Application for a Non-Material Amendment Following a Grant of Planning Permission

Householder planning application - a. single storey side extension b. single storey front extension c. installation of one window to front elevation d. installation of rooflights on front elevation

DC/22/1217/HH

Removal of 1 No. external door

Ref: JLD-RFB-B2A Date: MAR '24

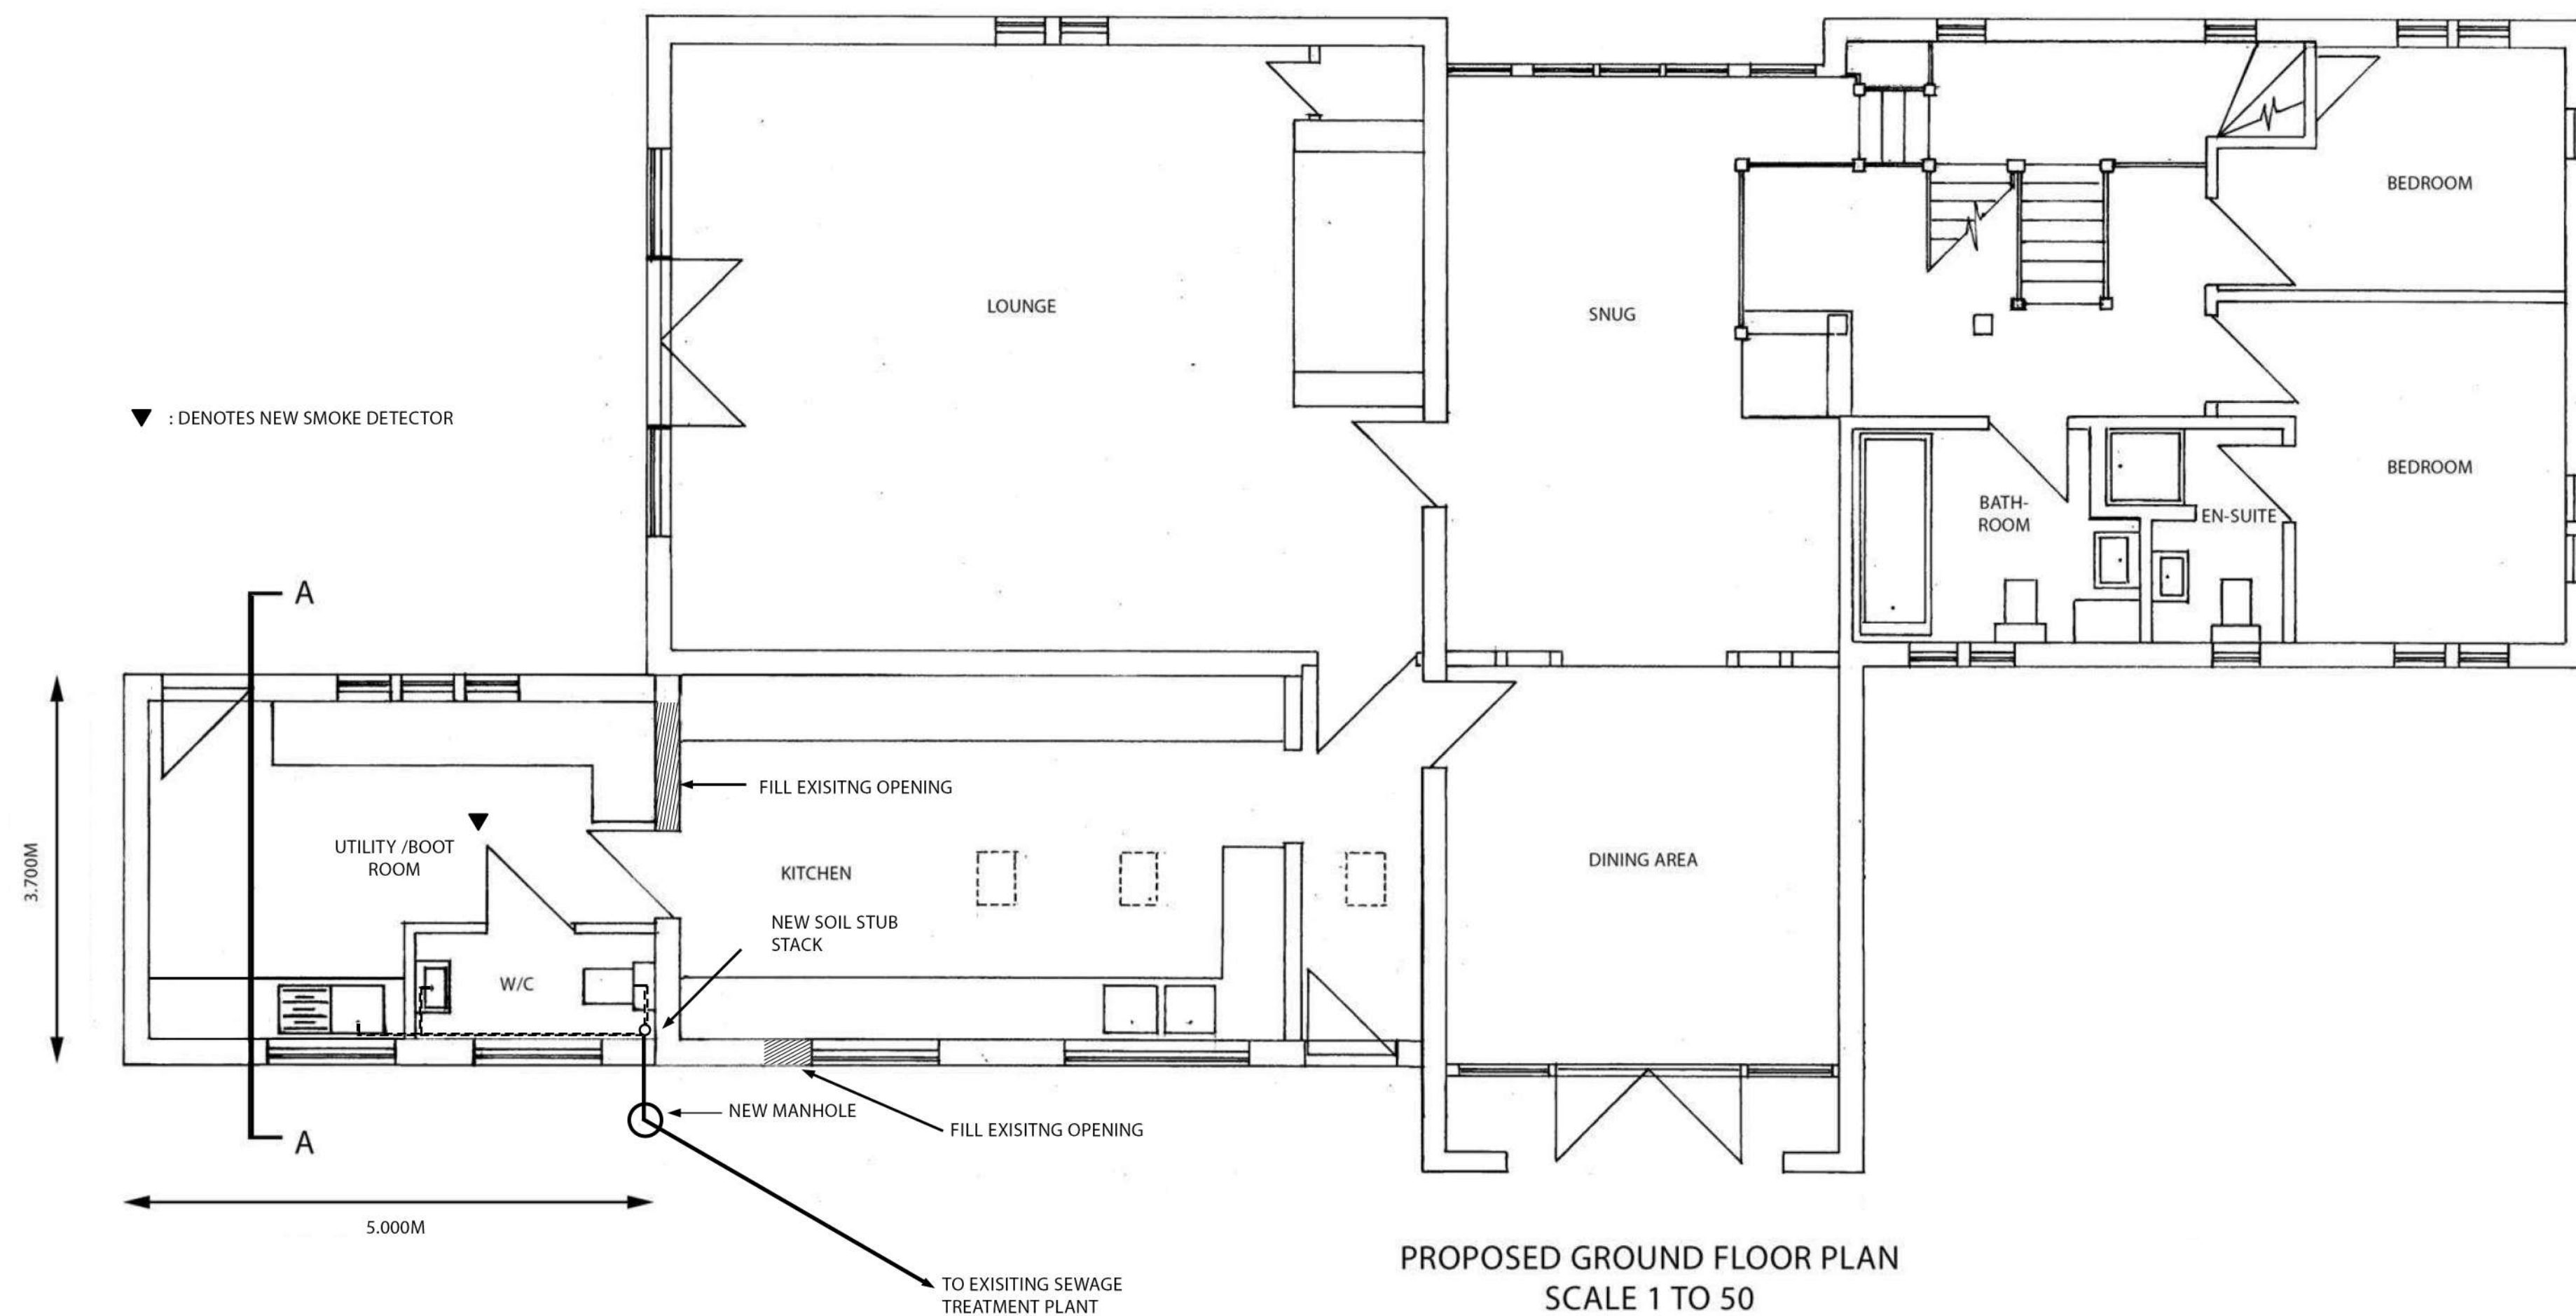
Door no longer required
